Application: SSI 7485

I write regarding the proposed modification to M4-M5 Link, Mod 2 The Crescent overpass and changes to pedestrian infrastructure in North Annandale, Rozelle and Rozelle Bay Foreshore area.

Figure 4-2 Pedestrian and cyclist bridge infrastructure options

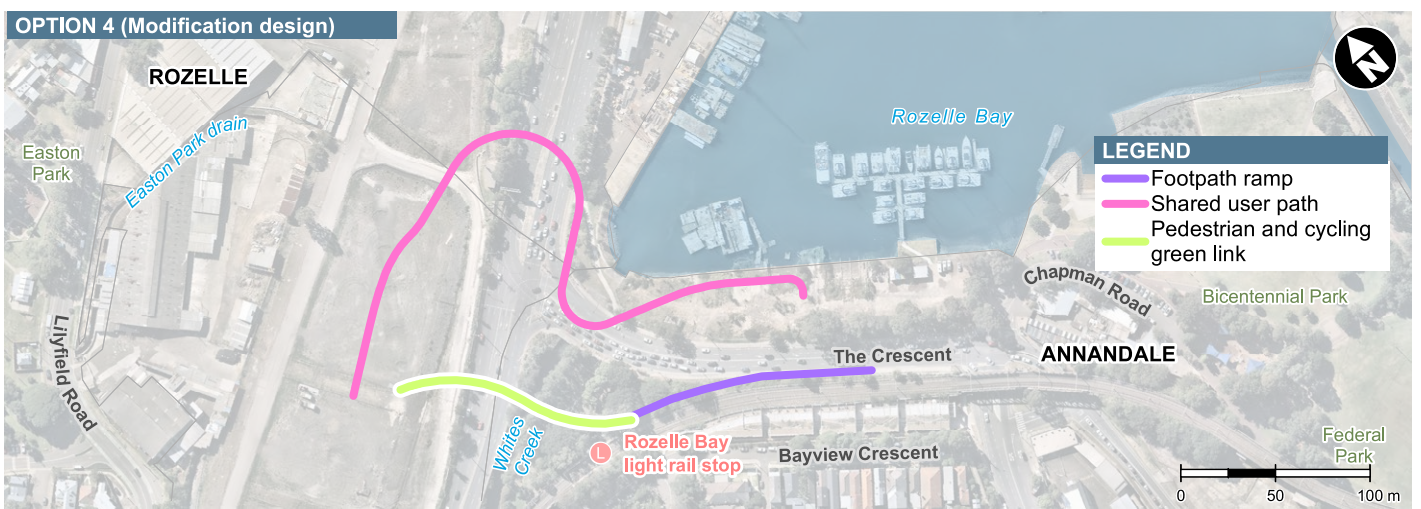
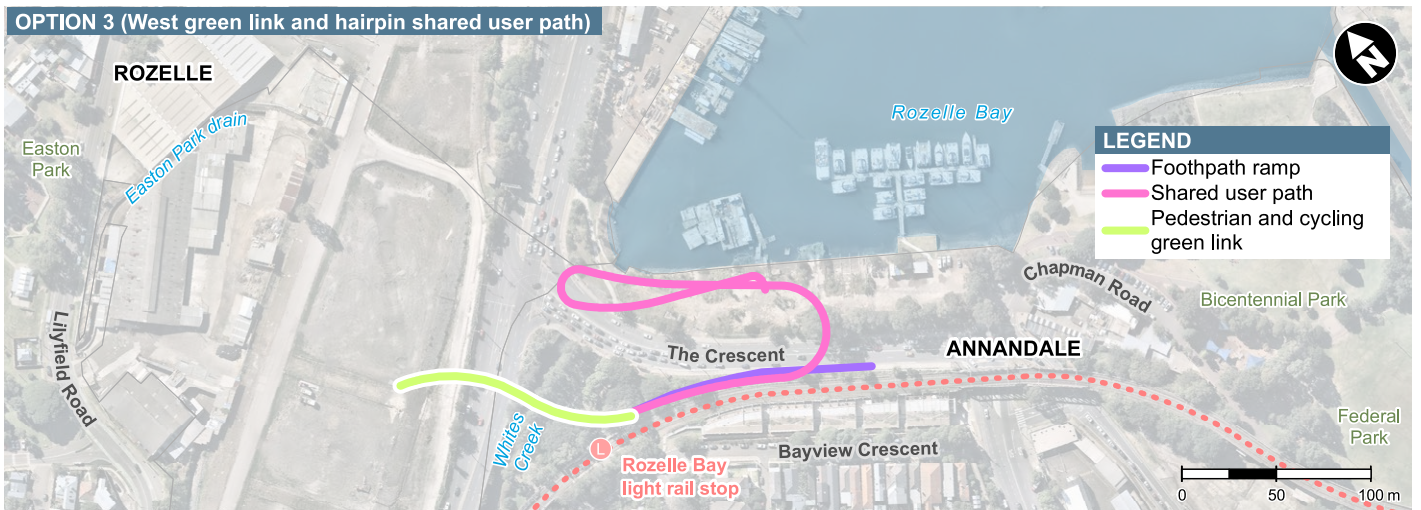
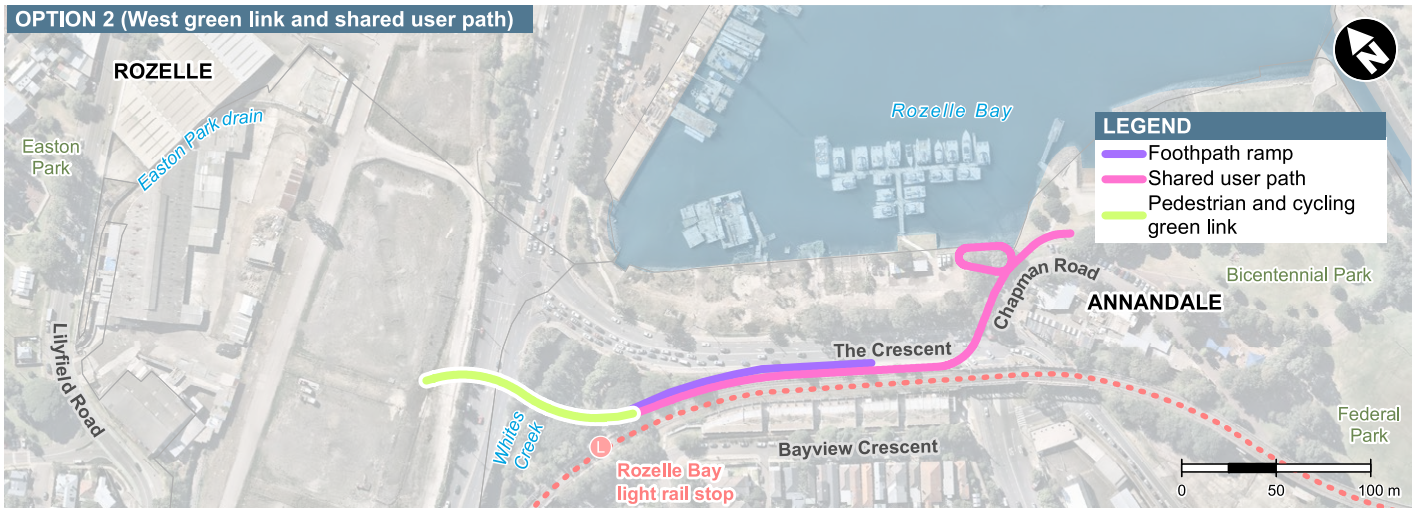
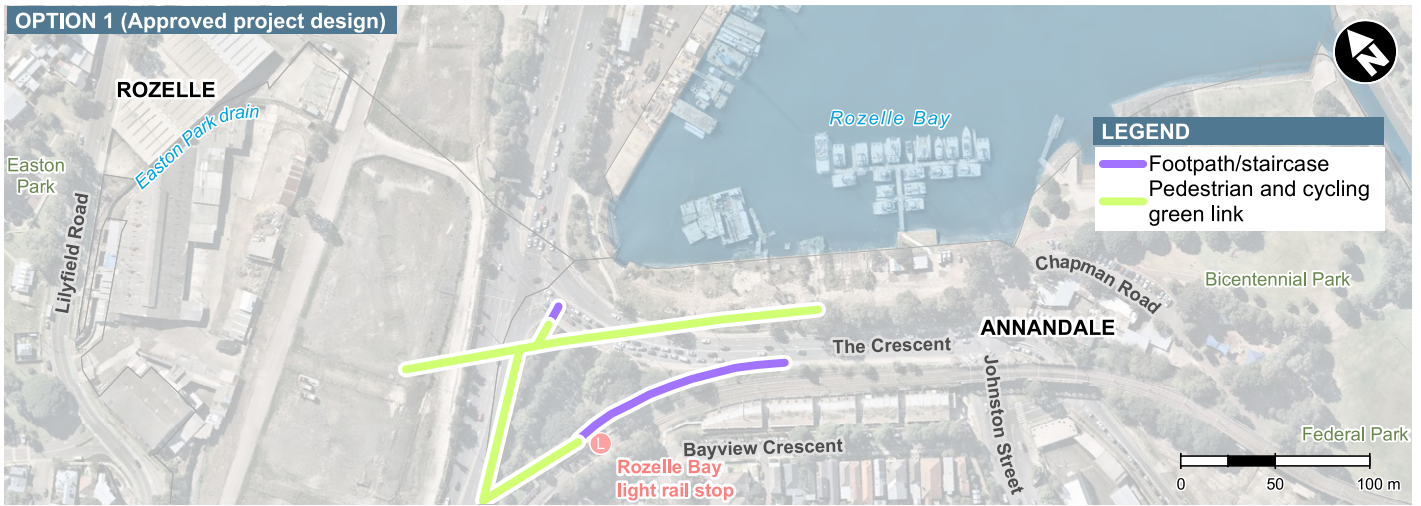
I request RMS work with the community to explore alternate design options to the proposed new car overpass design and the changed pedestrian and cyclist links. I am seeking the reinstatement of the safe, direct access from the approved EIS GreenLink to create a continuous green open space connection from the Rozelle Rail yards and Annandale to the foreshore. The GreenLink was more than just a walk way - it put people central to the design, maximising safety, and providing much needed accessible open space for the community now and into the future Bays Precinct design.

- The significantly reduced safety and increased risk for pedestrians and cyclists with removed access over The Crescent to Bicentennial Park and the increased traffic along Johnson Street.
- Being required to cross five sets of pedestrian lights at The Crescent as my option to reach the foreshore from Annandale or from Rozelle Bay light rail stop.
- Removal of direct active links to the foreshore, cutting the community off from the area and the proposed revitalisation of the entire Bays Precinct, including linking the Light Rail and Bus stops to a Ferry wharf and Metro station.
- Urban and landscape design that is being built before a finalised Masterplan for the area.
- Traffic changes that limit movements around the suburb and create further congestion in the local streets of Annandale, Forest Lodge, Glebe, Lilyfield and Rozelle with no planning to deal with these.

- Reinstatement the GreenLink connecting communities and green open space from Rozelle to Bicentennial Park
- Relocate and design pedestrian and cyclist connections that are continuous, safe and direct.
- Design the modification infrastructure and active links in response to the character of the suburbs, the location of the foreshore and its potential future development.
- Provide pedestrian and cyclist paths that maximise people safety and do not force them onto busier streets, unsafe concrete plazas and caged walkways.
- Integrate active and direct connections to all active transport - including the future Metro West and Foreshore Ferry Wharf

Figure 4-4 Elevation: Indicative view of The Crescent overpass

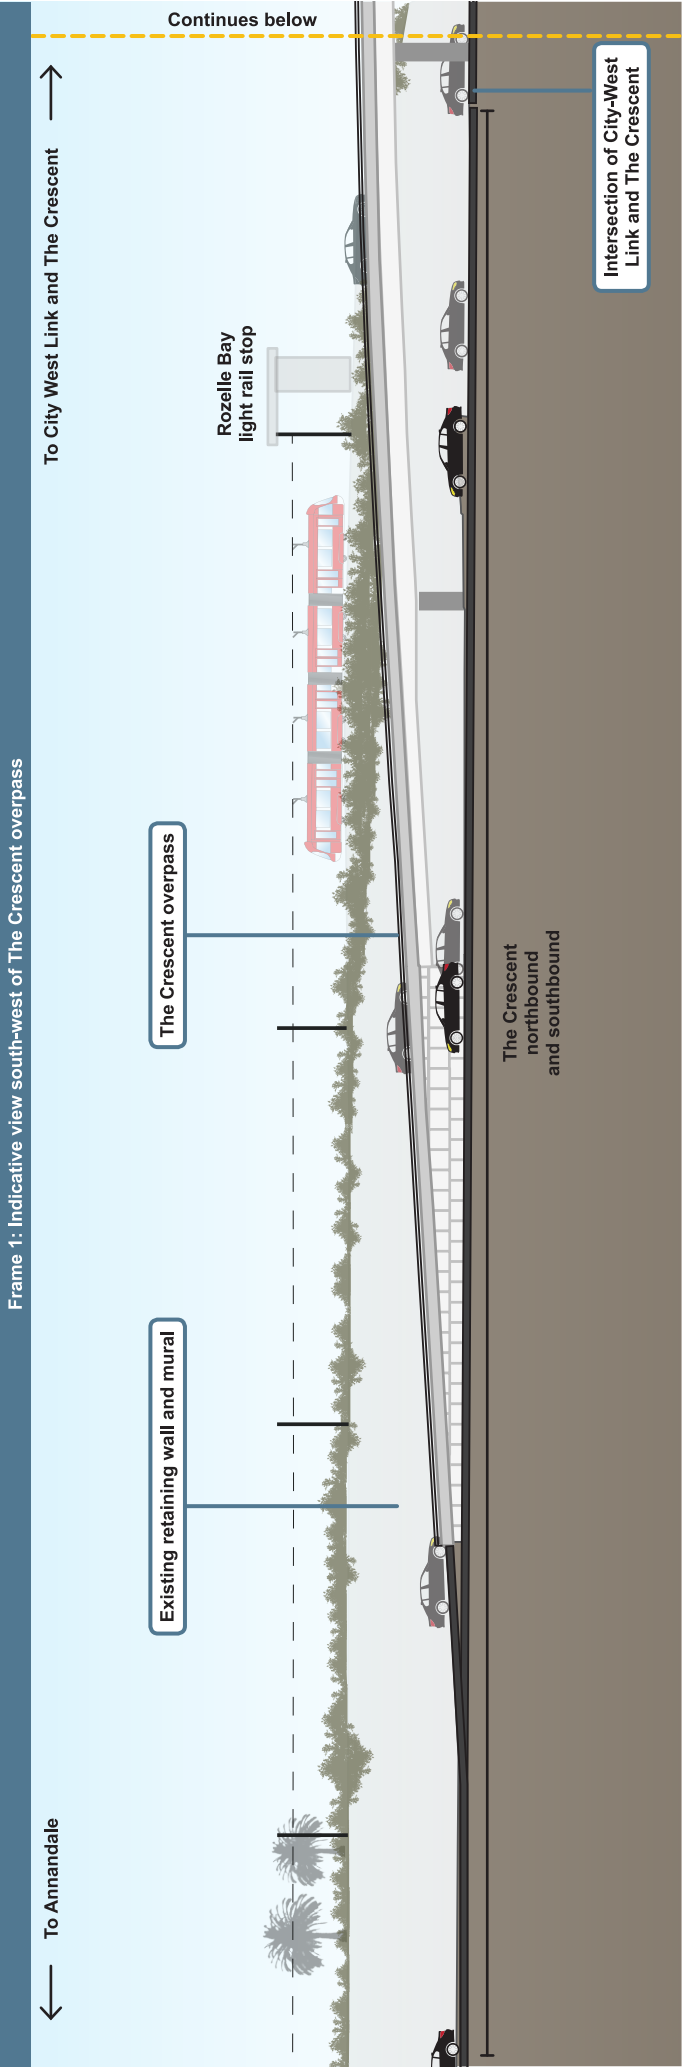
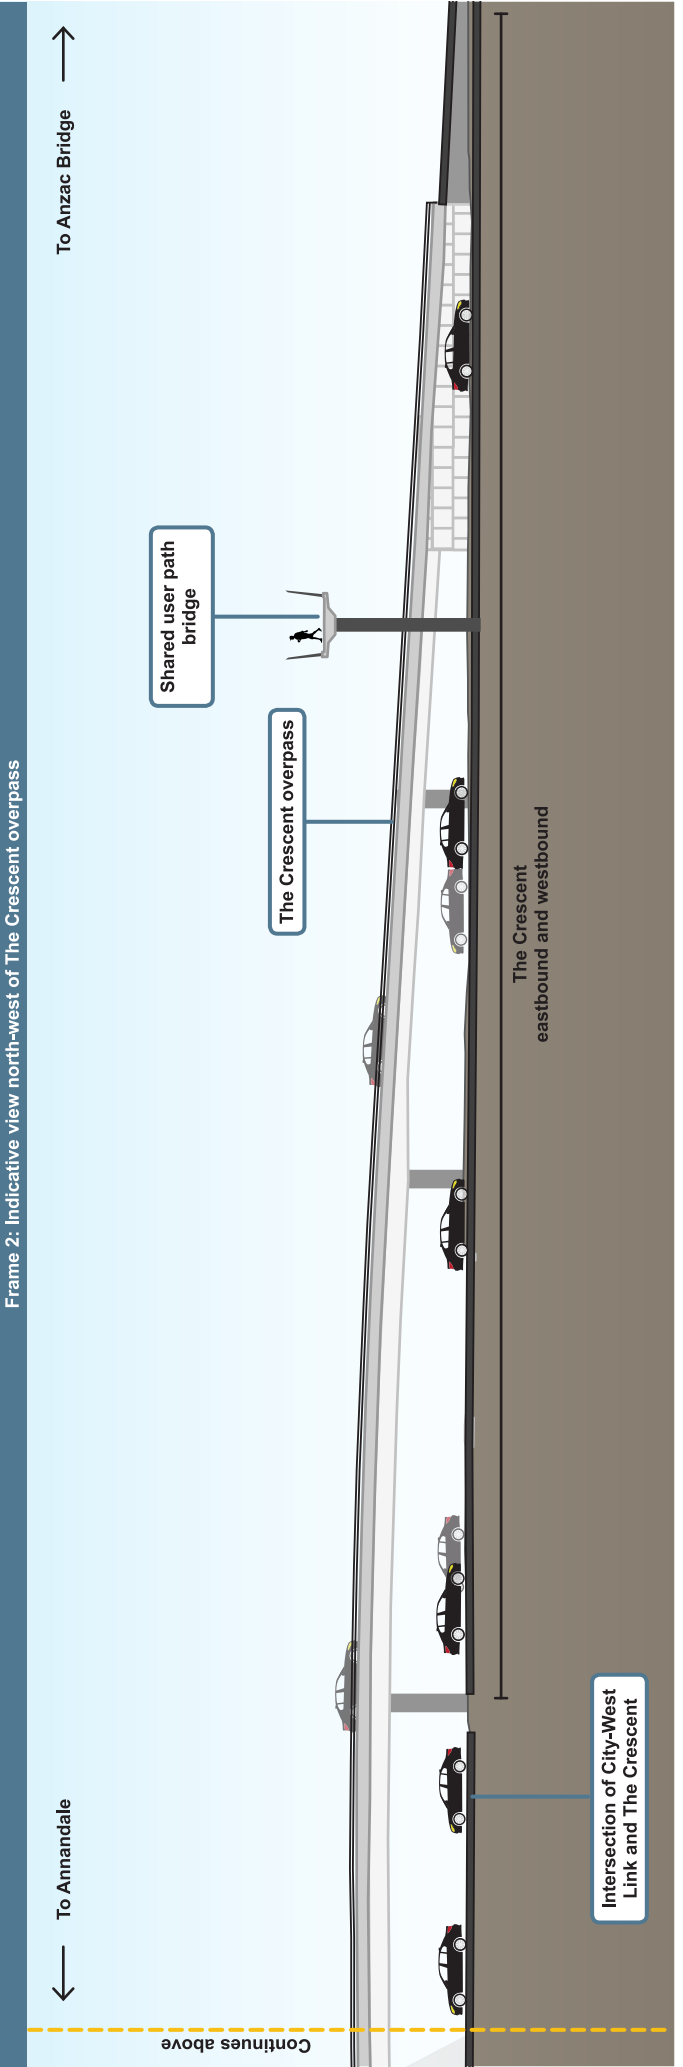
Why are we bothering the Inner West Council with the Lilyfield Cycleway and other water connect up bicycle projects when this project seems to be making things up as it goes along. You have approved for a design and a project brief and we expect much better of the design team than throwing up this ugly ad hoc overpass without due consideration and consultation or a very poor design outcome. If overall project management and design is not up to this major engineering task, let's face it - let's just wait until you actually are able to thoroughly design & integrate a plan we can all live with.
